# Summary of Comments on P:\100\100.067\constr\street \100.067-COVER-street-STM C0.1 (1)

TYPICAL SECTIONS

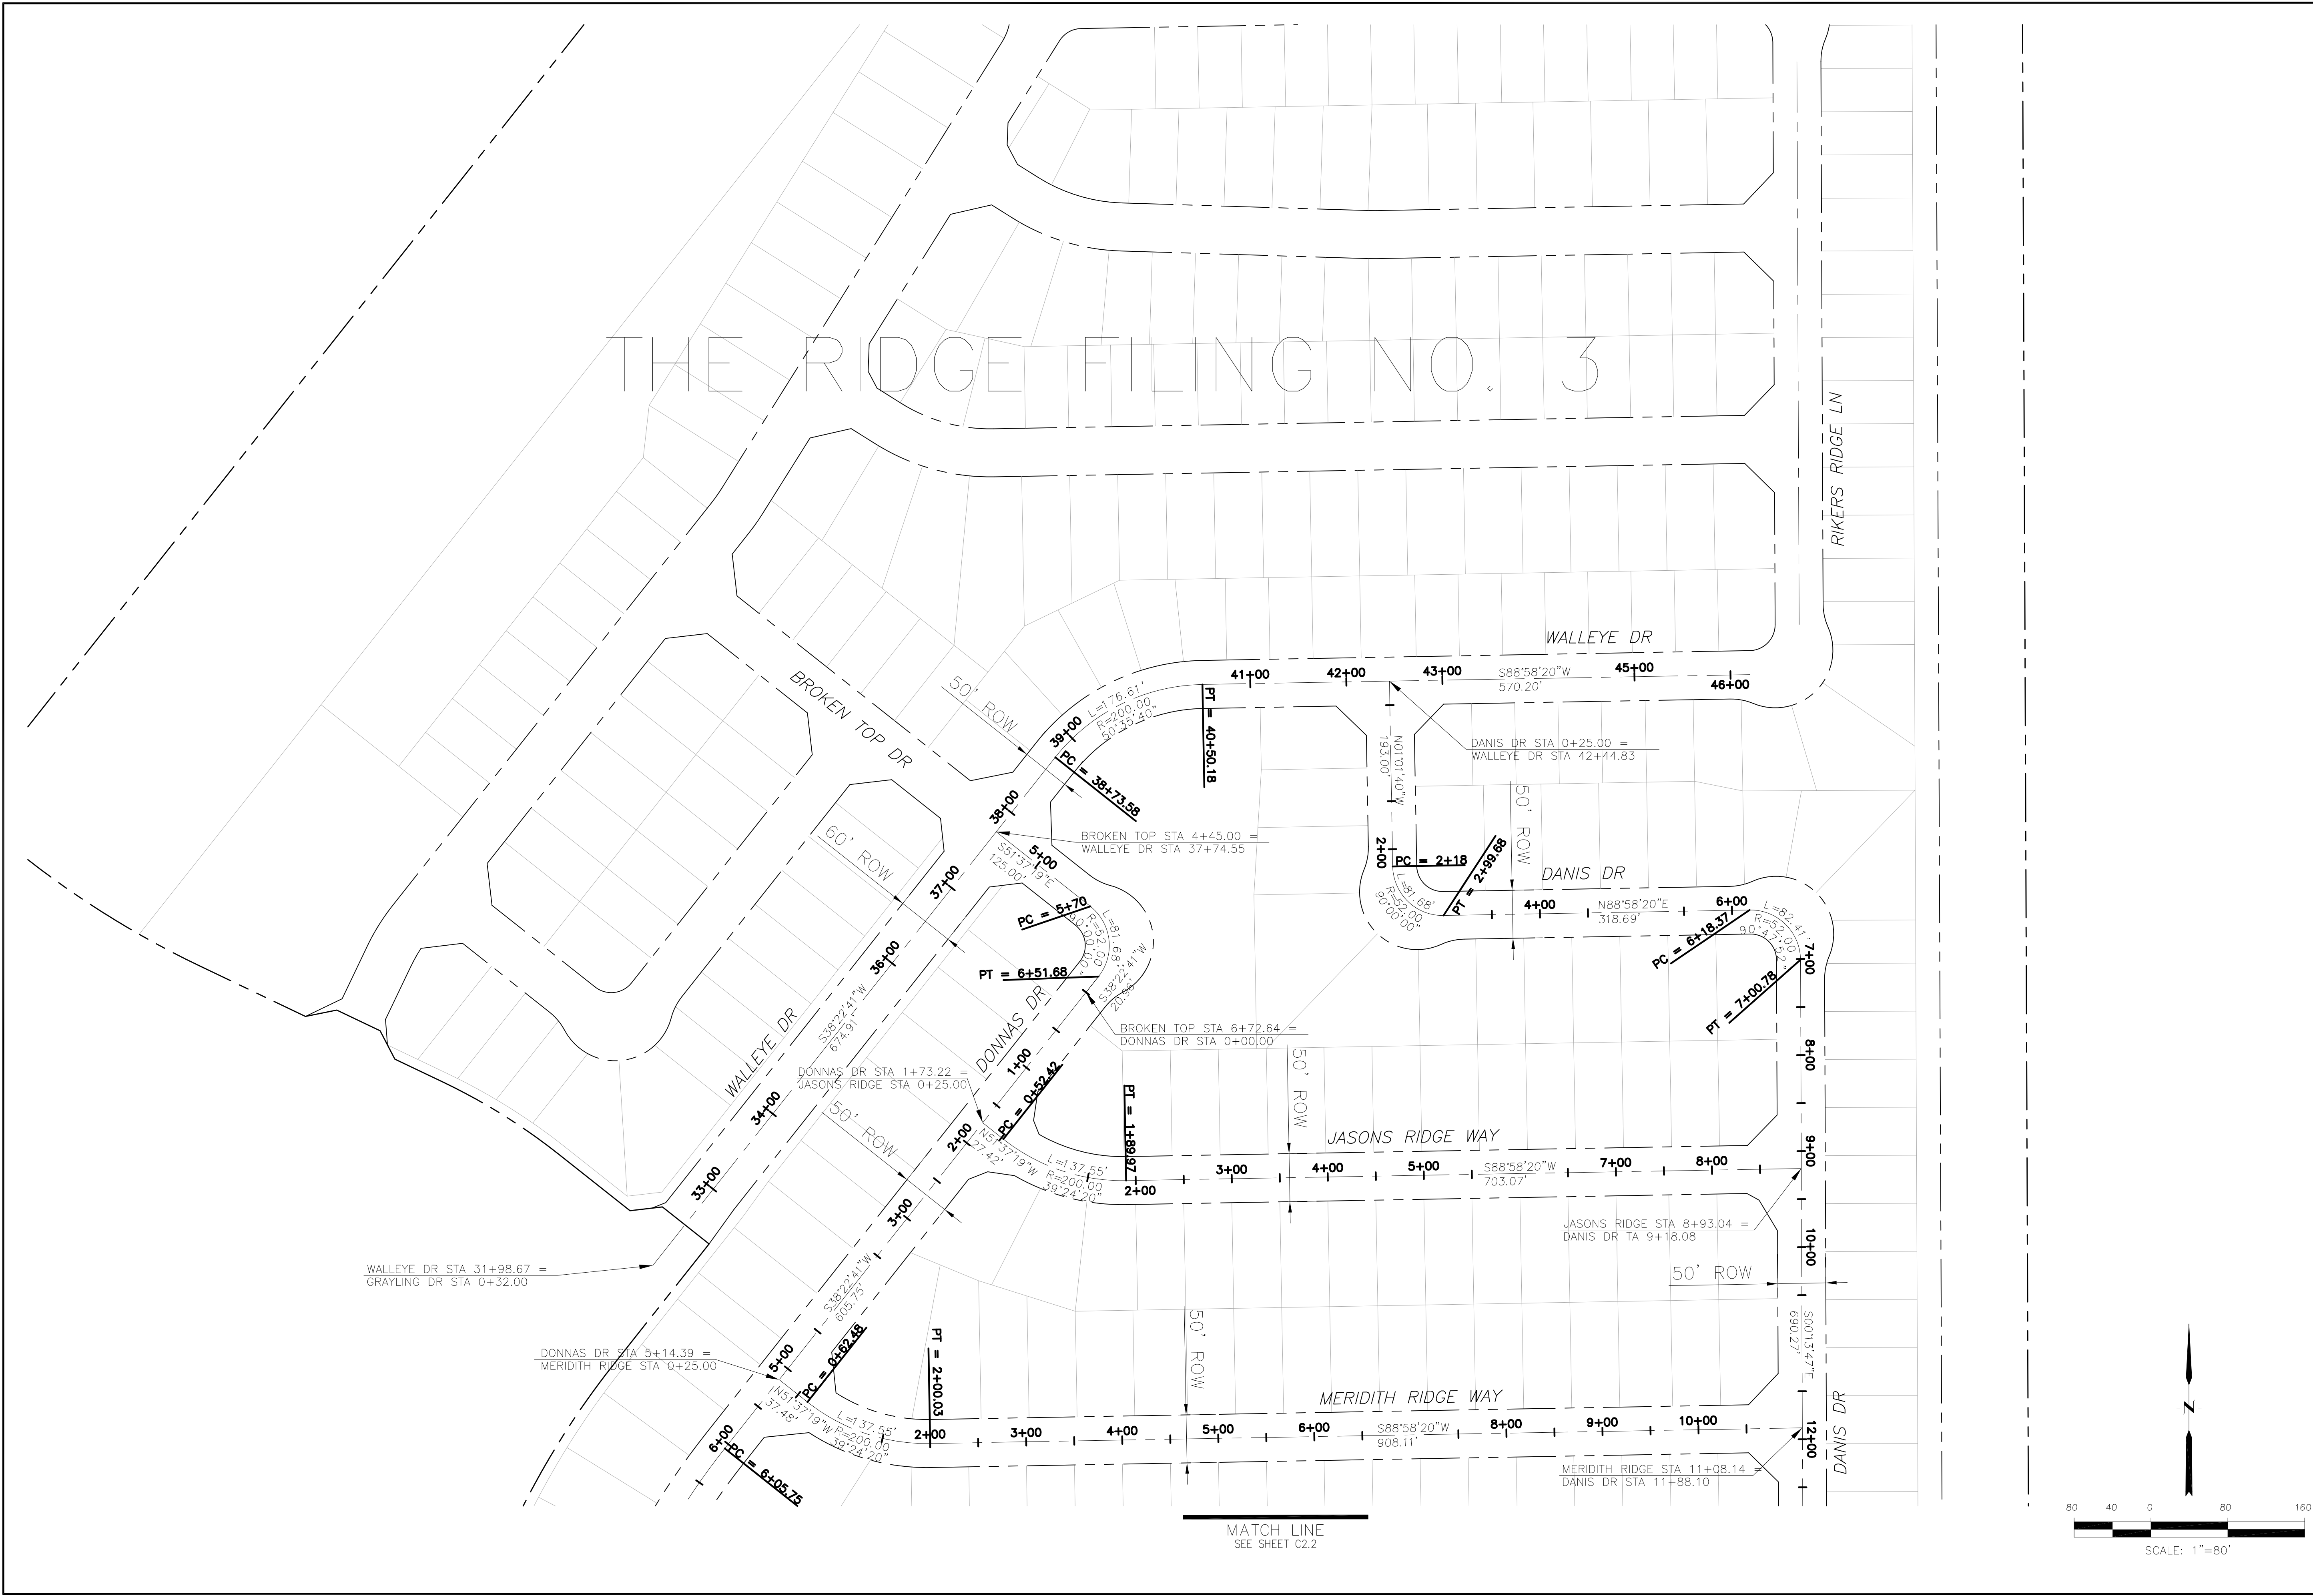
According to comment responses, Walleye was downgraded to a local street. Please revise and update posted and design speeds.

BROKEN TOP DRIVE

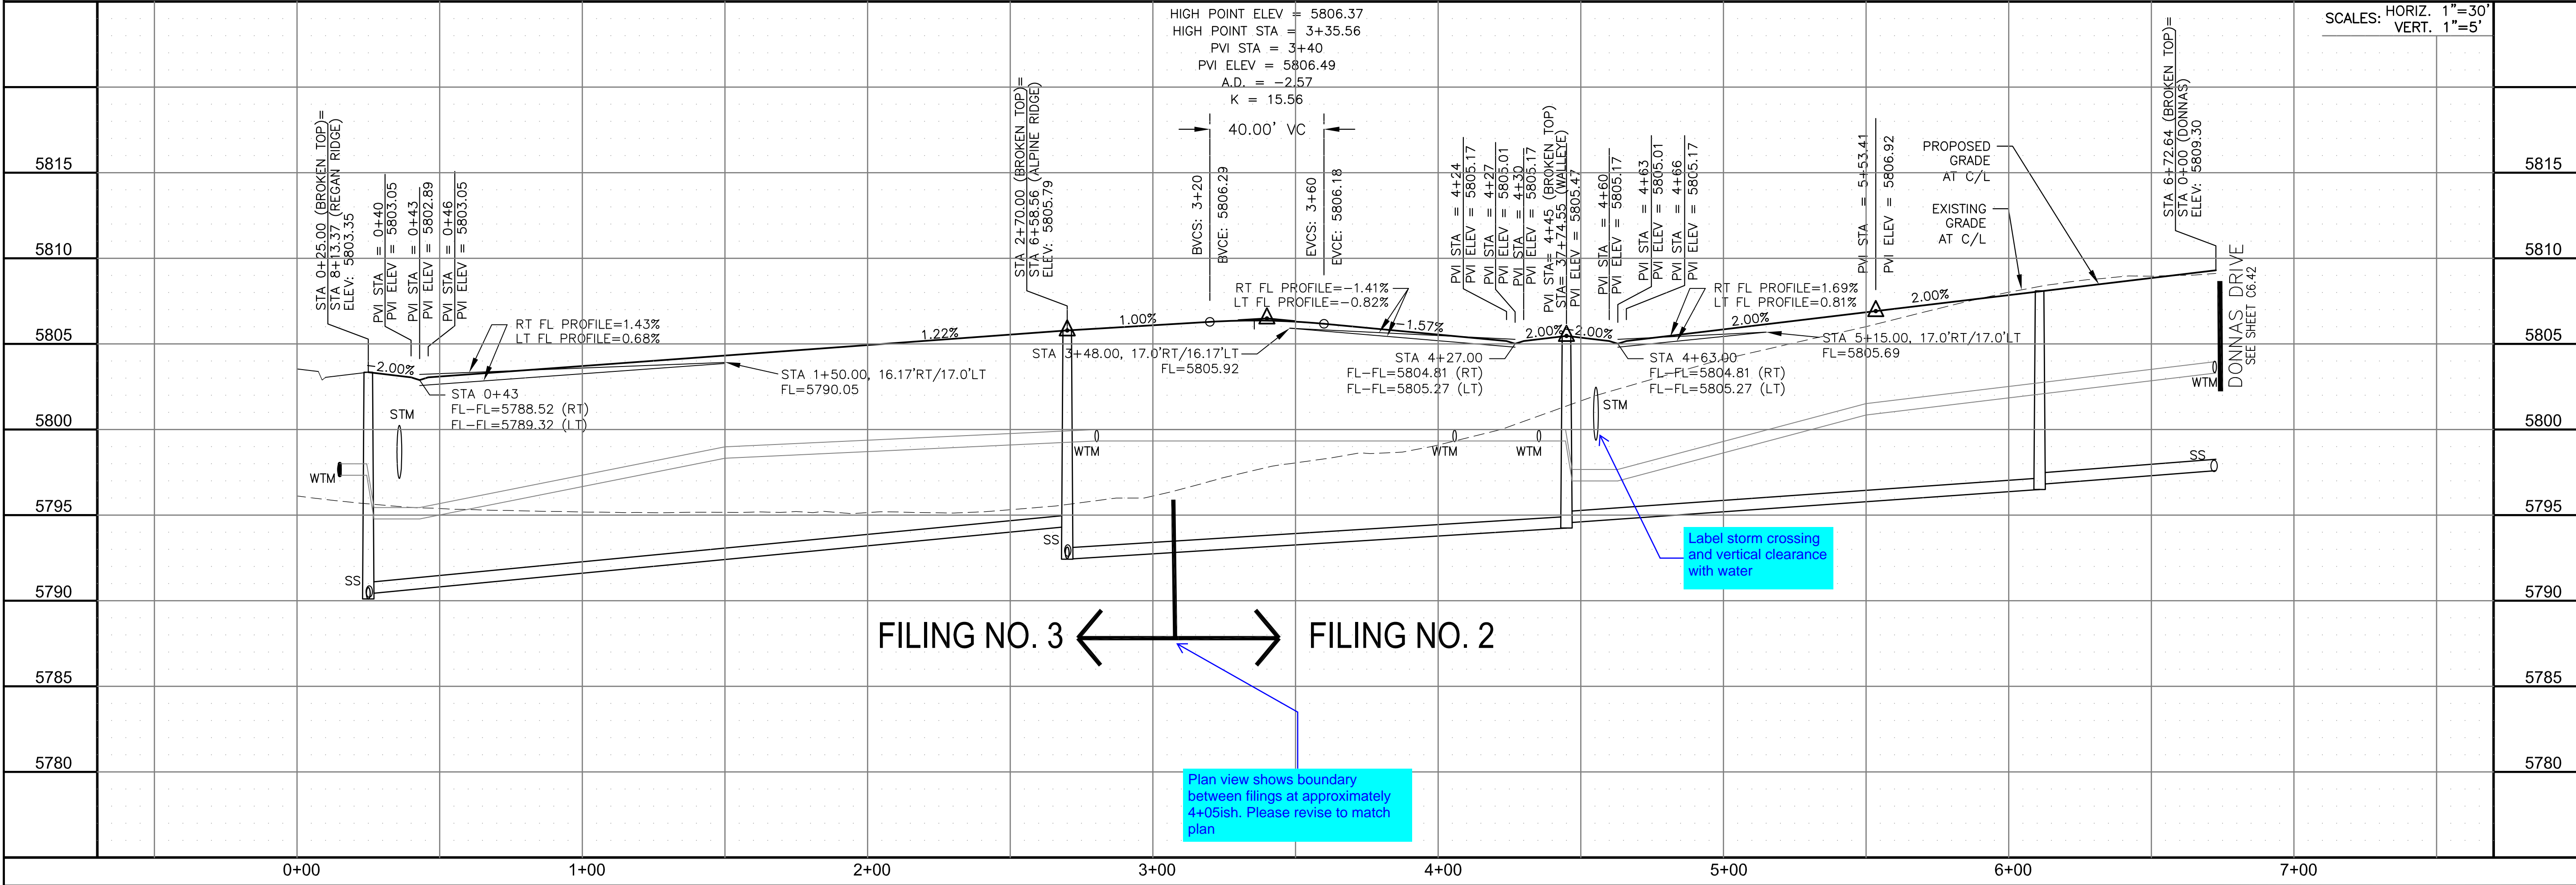
- Author: lpackman Subject: Text Box Date: 5/3/2022 8:54:00 AM  
Unresolved. Lengths & inverts do not match FDR

- Author: lpackman Subject: Callout Date: 5/3/2022 8:54:18 AM  
Unresolved. Inverts do not match FDR

- Author: RSchindler Subject: Sticky Note Date: 6/3/2022 8:25:40 AM  
MODEL UPDATED

- Author: RSchindler Subject: Sticky Note Date: 6/3/2022 8:24:35 AM  
MODEL UPDATED

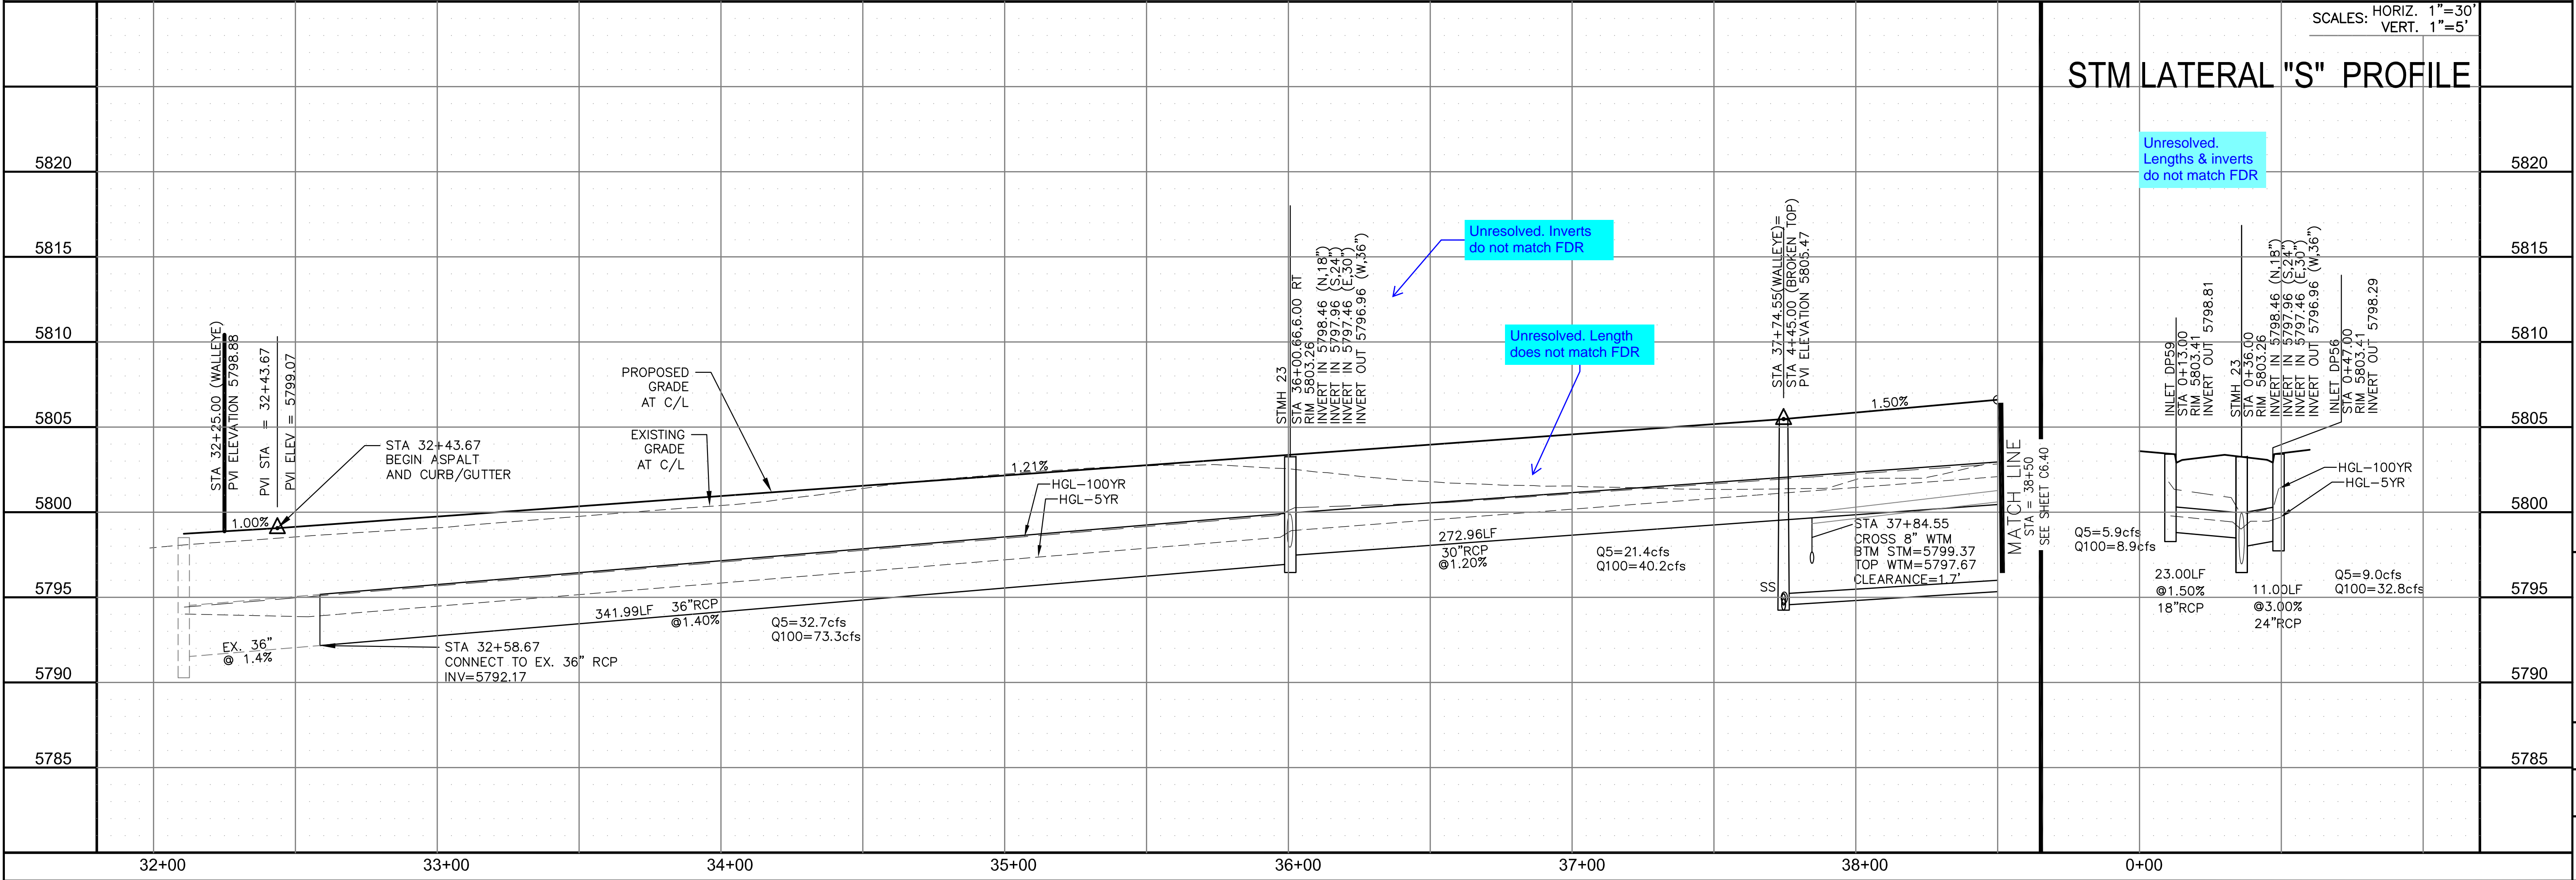
- Author: lpackman Subject: Callout Date: 5/3/2022 8:54:29 AM  
Unresolved. Length does not match FDR

- Author: RSchindler Subject: Sticky Note Date: 6/3/2022 8:24:42 AM  
MODEL UPDATED

DONNAS DRIVE

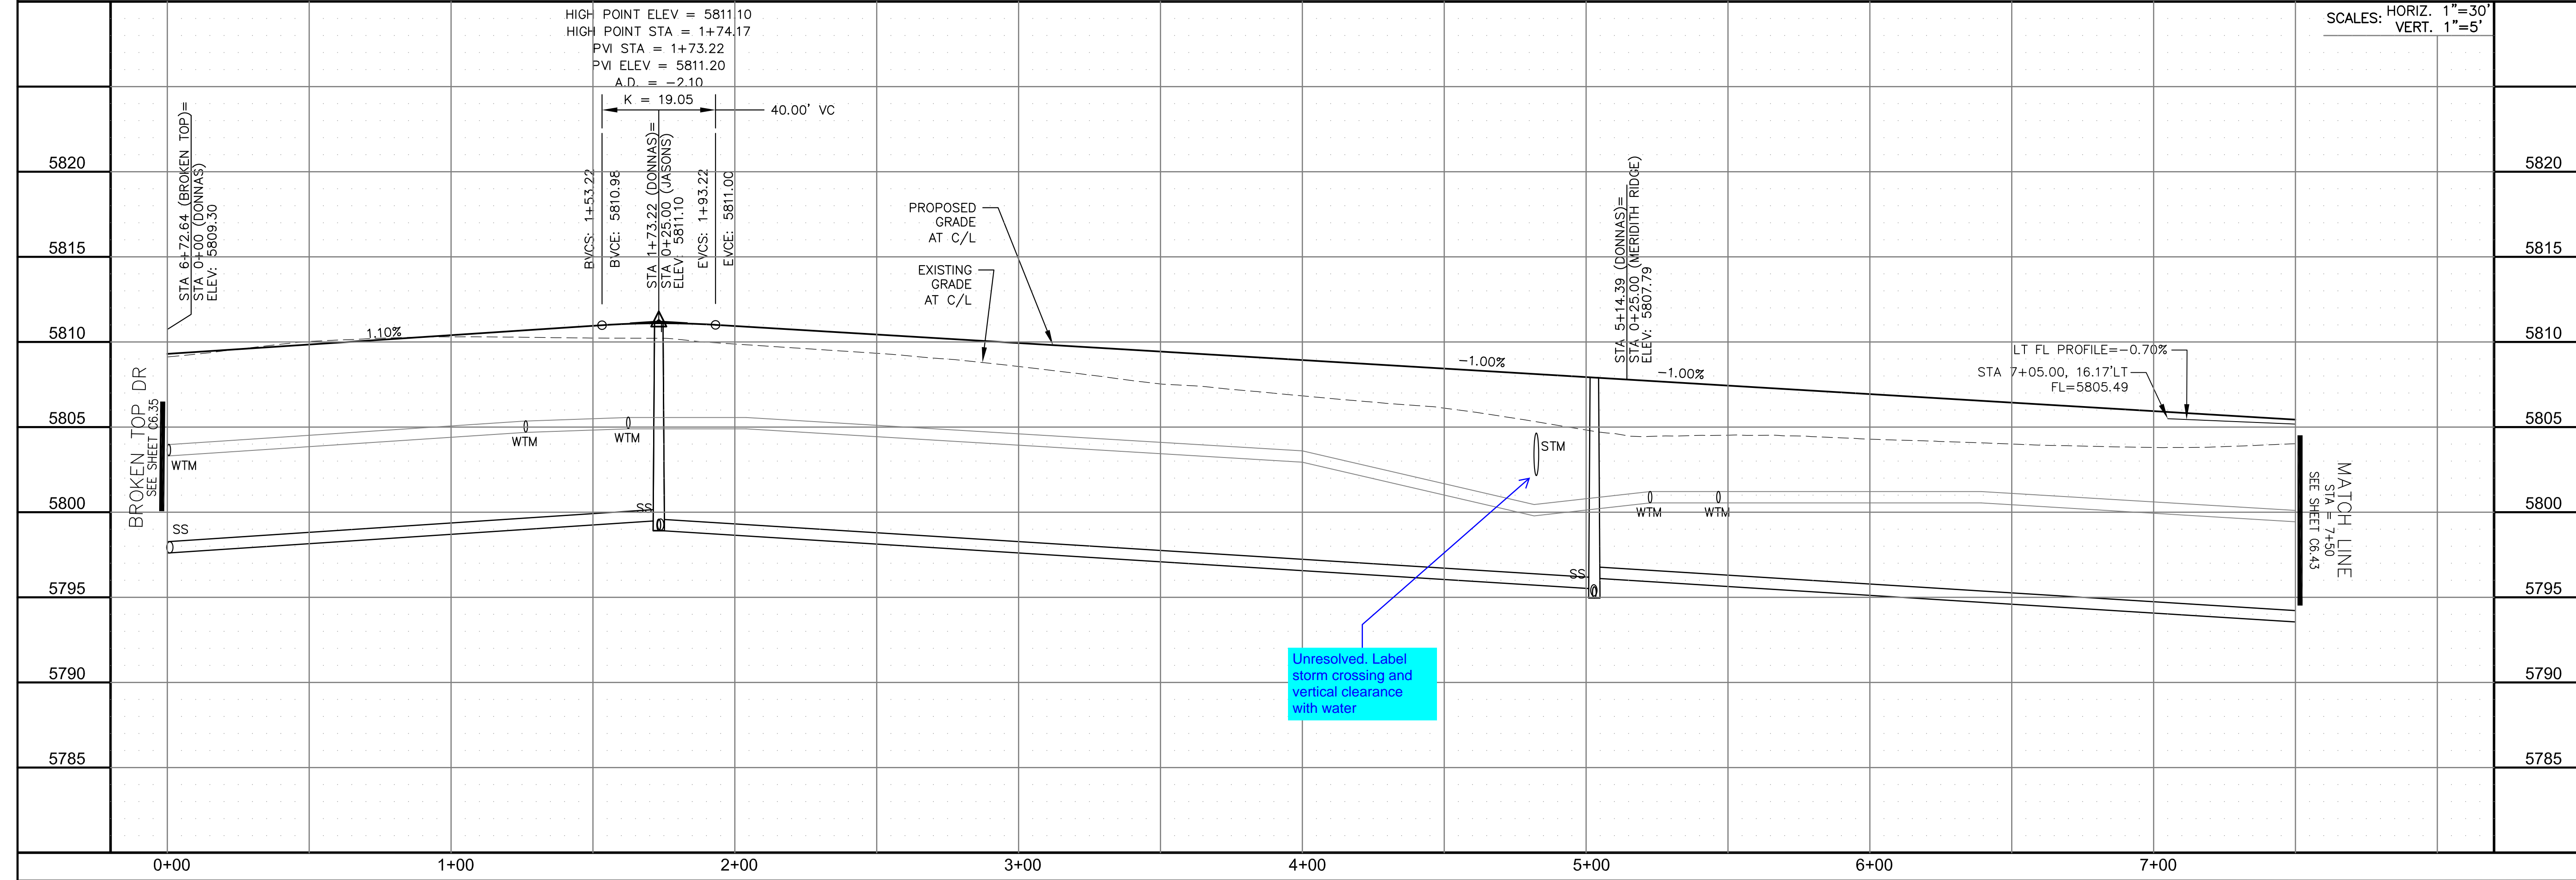
- Author: Ipackman Subject: Text Box Date: 5/3/2022 8:56:42 AM  
 Unresolved. Show and clearly identify boundary between Filing 2 and 3
- Author: RSchindler Subject: Sticky Note Date: 6/3/2022 8:30:55 AM  
 SHEET 6.35 HAS THAT LABEL
- Author: CDurham Subject: Callout Date: 5/5/2022 2:57:31 PM  
 Revise ROW lines so sidewalk is located within it.
- Author: RSchindler Subject: Sticky Note Date: 6/3/2022 8:36:48 AM  
 ROW updated
- Author: Ipackman Subject: Callout Date: 5/3/2022 8:57:08 AM  
 Unresolved. Label storm crossing and vertical clearance with water
- Author: RSchindler Subject: Sticky Note Date: 6/3/2022 8:37:46 AM  
 labeled
